MEMORANDUM

PROJECT: NEW PRIMARY SCHOOL IN EDMONDSON PARK
JOB NO.: 210002

Date: 12 Aug 2021

SUBJECT NEW PRIMARY SCHOOL IN EDMONDSON PARK SSDA – RESPONSE TO SUBMISSIONS

Drawing No.
AR W-DW- 2001

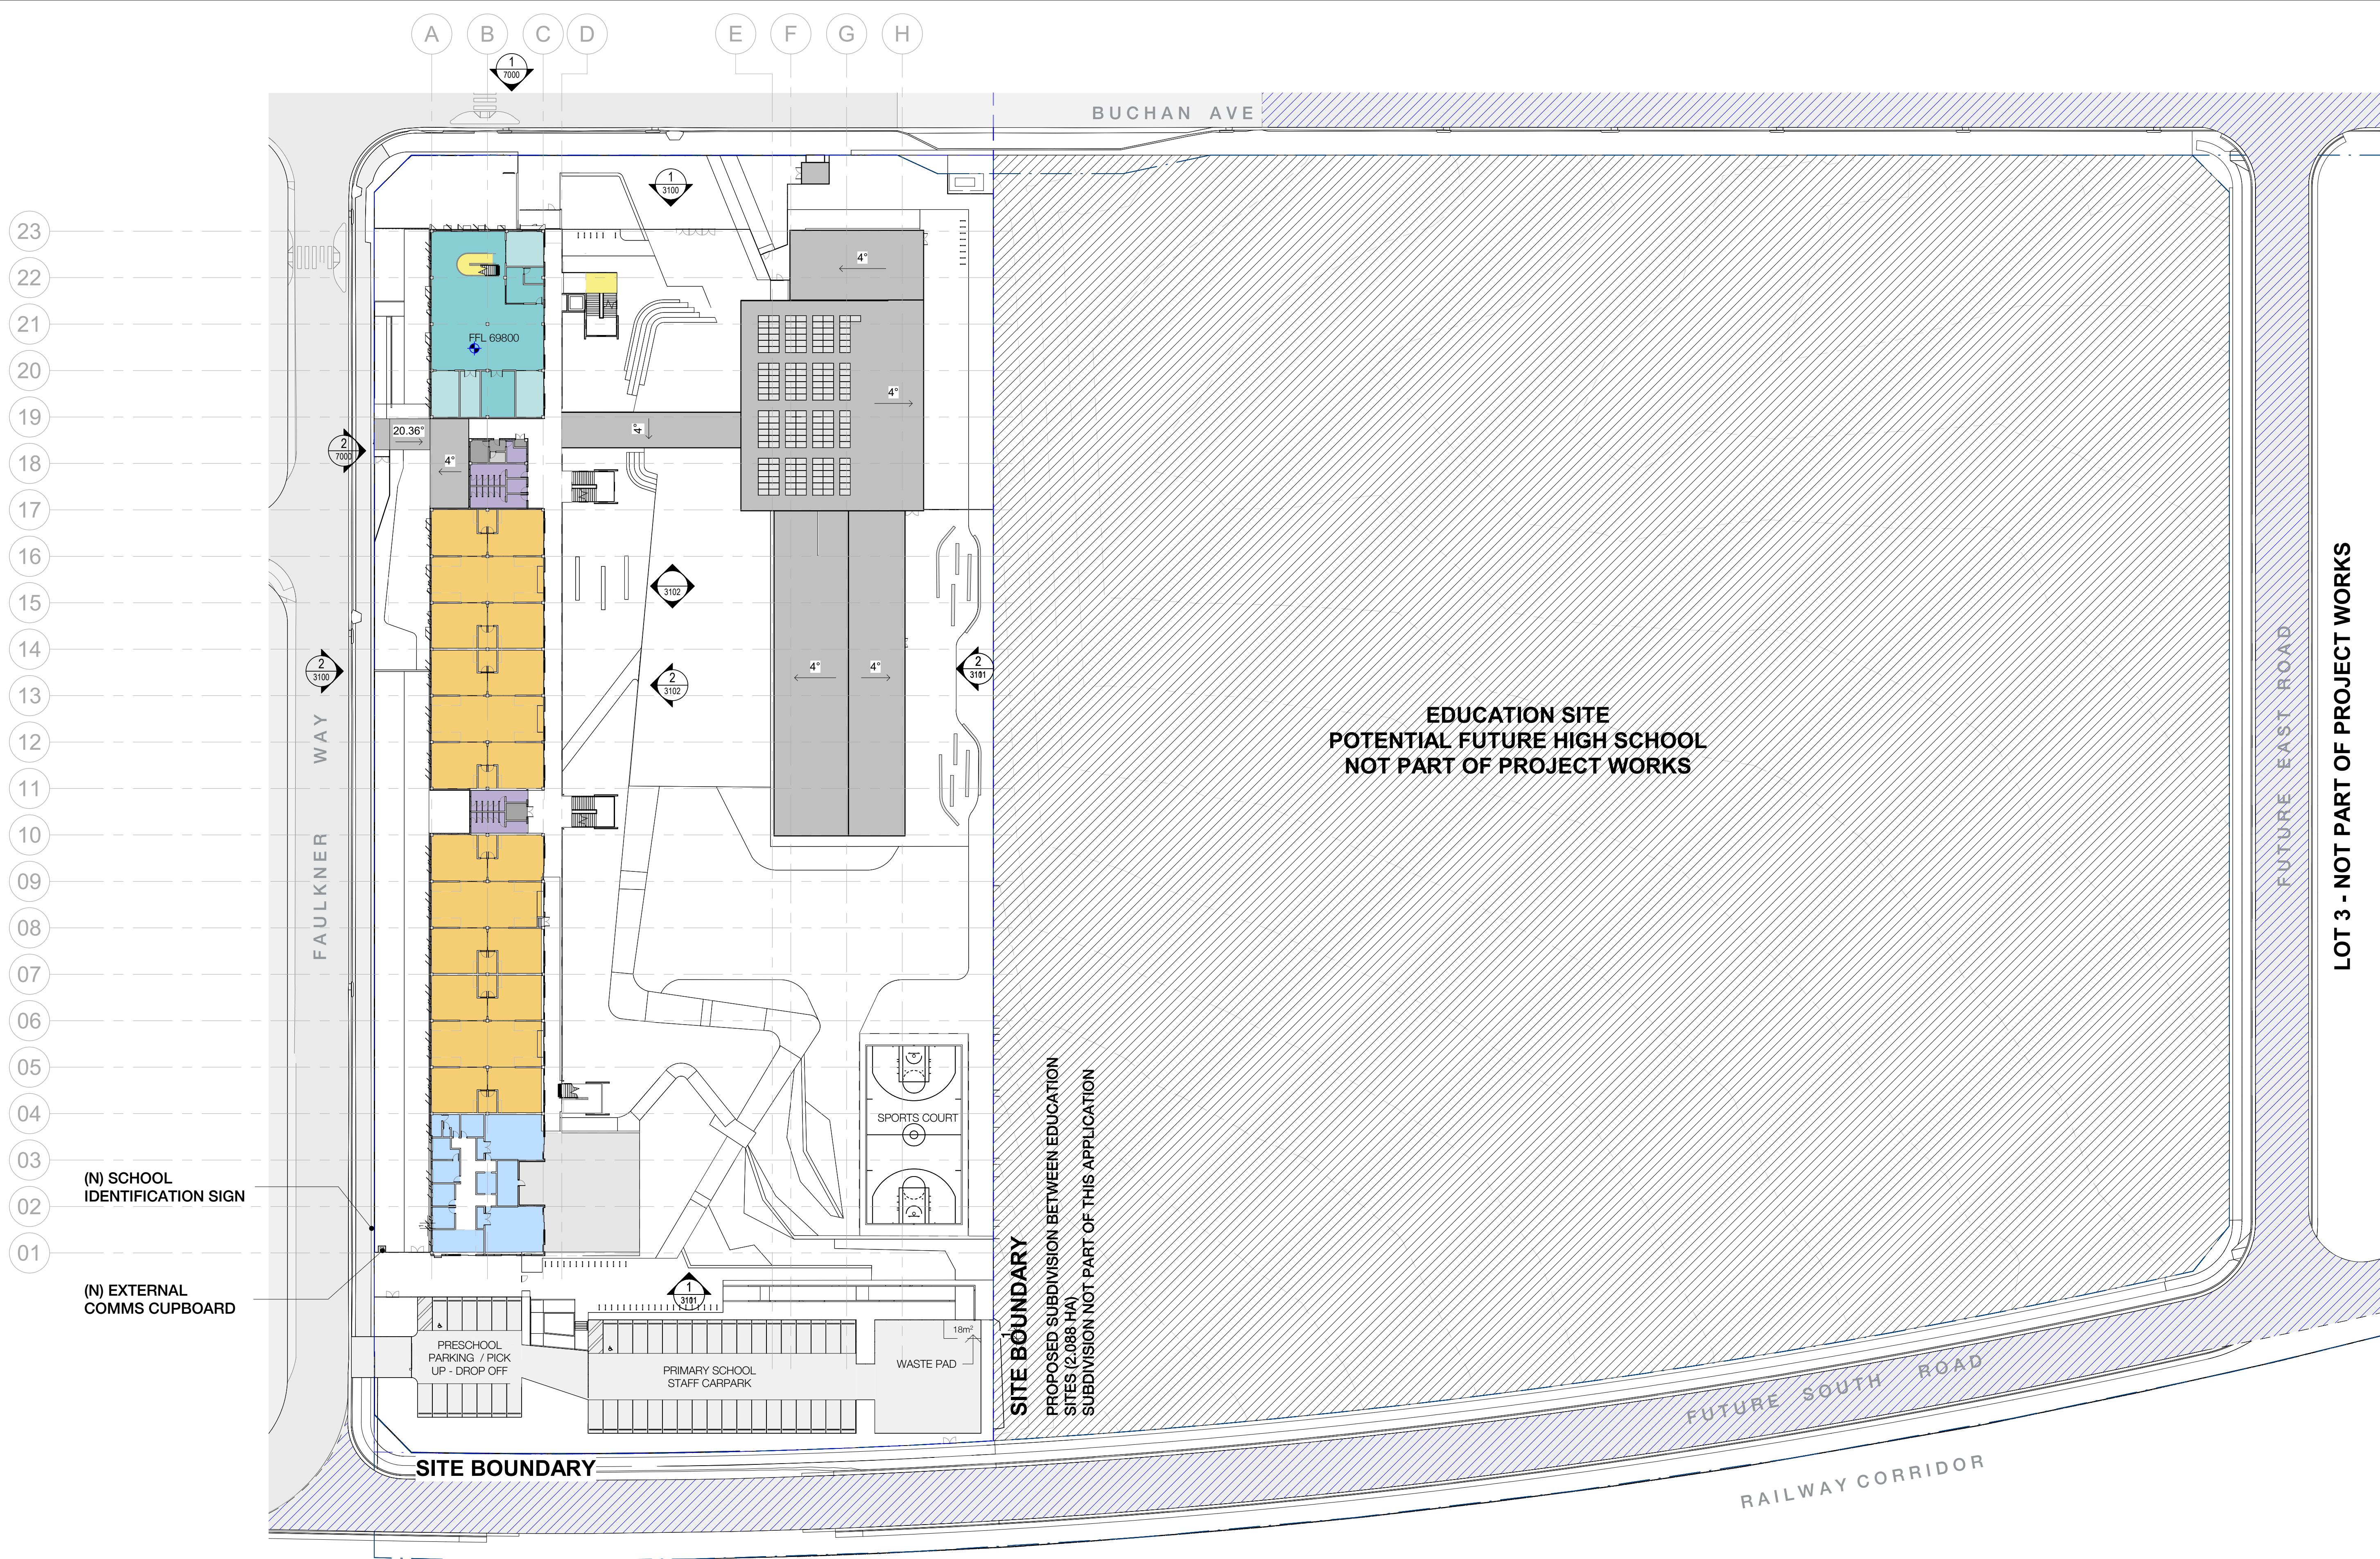
1. SDRP Comments
Government Architect NSW
SDRP Session 79 – 23.06.21 (second SDRP review)
Advice Letter – 30 July 2021
 - a. Item 7. The Faulkner Way entry was not supported as currently illustrated. Provide a more welcoming and readily identifiable entry (in the context of the façade's uniformity), include weather protection via awnings or other elements.

- b. For all arrival scenarios (e.g. staff, visitors and students with access needs), ensure equitable and accessible routes within the site are available, include dignity issues of directness and weather protection. Specifically address the route from the southern entry /car park to the southern end of the main north-south building.

The Faulkner Way entry alcove has increased in length and width, presenting a larger gathering space. The awning over the Support Unit outdoor play space has been extended to provide weather protection to the Faulkner Way entry. The proposed awning will be of the same materiality and colour palette as the Buchan Avenue window solar shading devices. The bastille type fence along Buchan Avenue has been extended to include the Faulkner Way entry alcove, which visually connects the two school entry points. The prominence of the awning with appropriate School Identification signage will provide a more welcoming and identifiable entry to the school along Faulkner Way.

The accessible parking for Staff Carpark has been relocated so that it has a closer and more direct path to the southern end of Block A. The ramp and stair access from the carpark will be co-located to ensure there is an equitable approach to the school grounds from the carpark.

2 NORTH - WEST ELEVATION (FAULKNER WAY)
0005 1 : 250

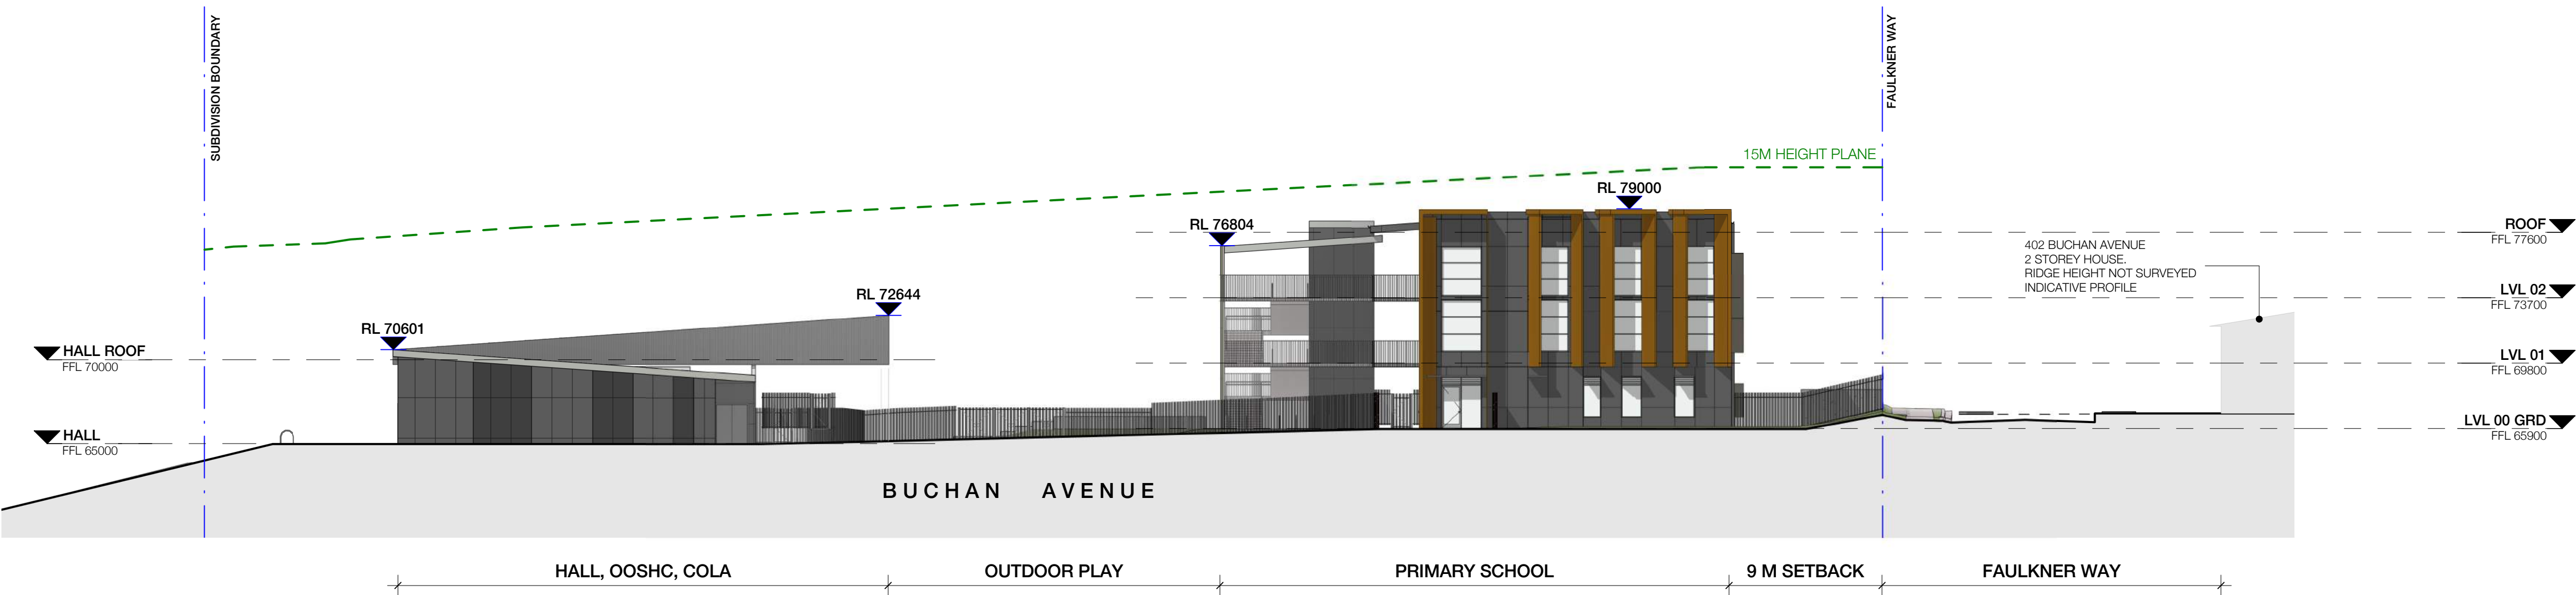
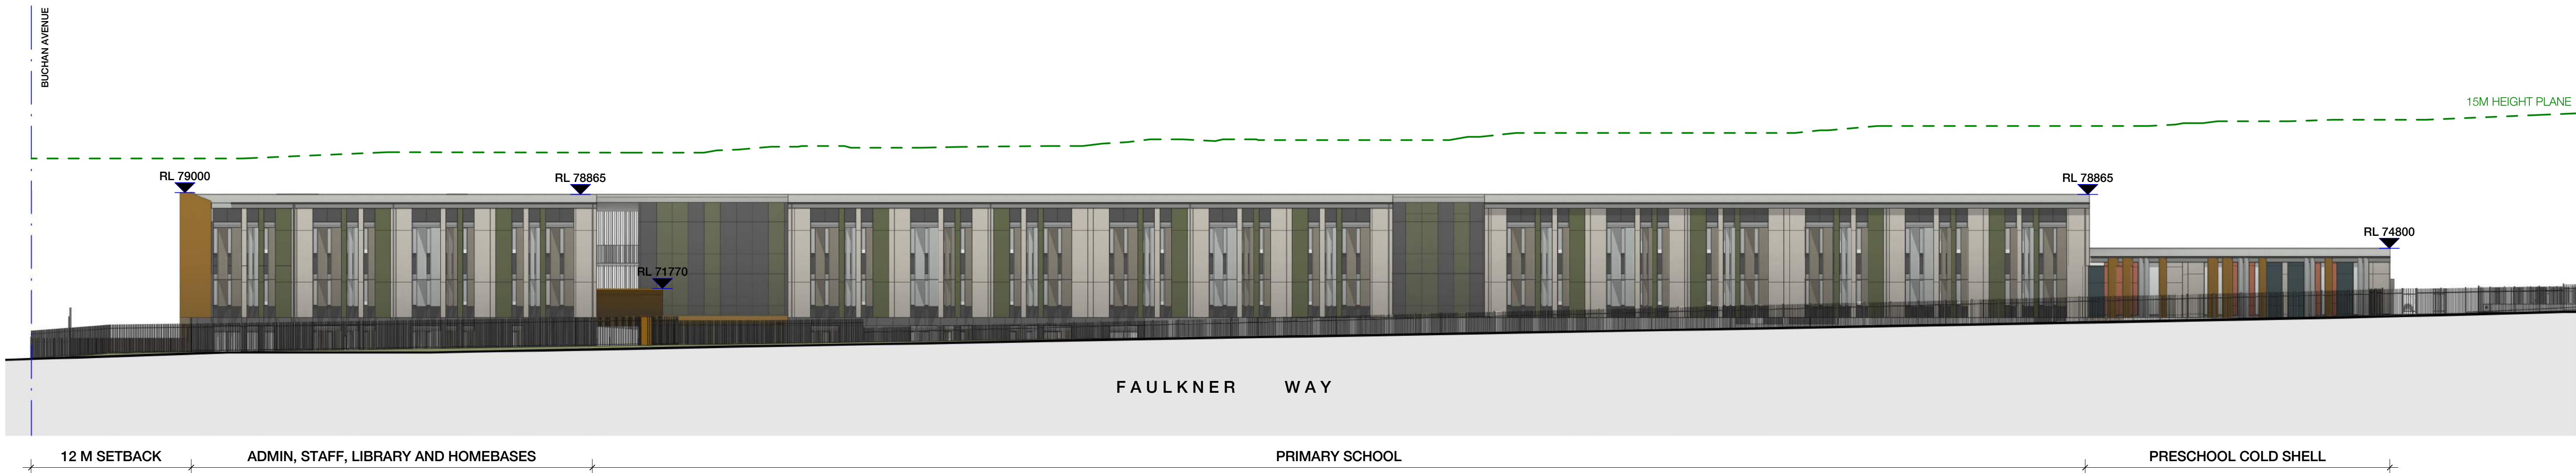
- b. Additional consideration should be given to design opportunities that may break the uniformity of the Faulkner Way elevation, when viewed from Gallipoli Drive, which is contributing to the perceived bulk and scale of the school.

The introduction of the awning will be viewed from Gallipoli Drive. The colour of the awning identifying the entry to the school from Faulkner Way contrasts against the building façade colours. This will be a prominent feature that breaks the visual uniformity of the Faulkner Way elevation.

Dark contrasting materials can also be used along the sides of the building recesses along Block A to add depth in the appearance of the façade. Vegetation and planting along Faulkner Way and within the play space will provide variation and contrast along the elevation.

The rationalisation and reduced height of the sunshades along the Faulkner Way elevation enables more visibility of the building cladding. This emphasises the layering of different materials on the façade and helps reduce the visual bulk and scale of the building.
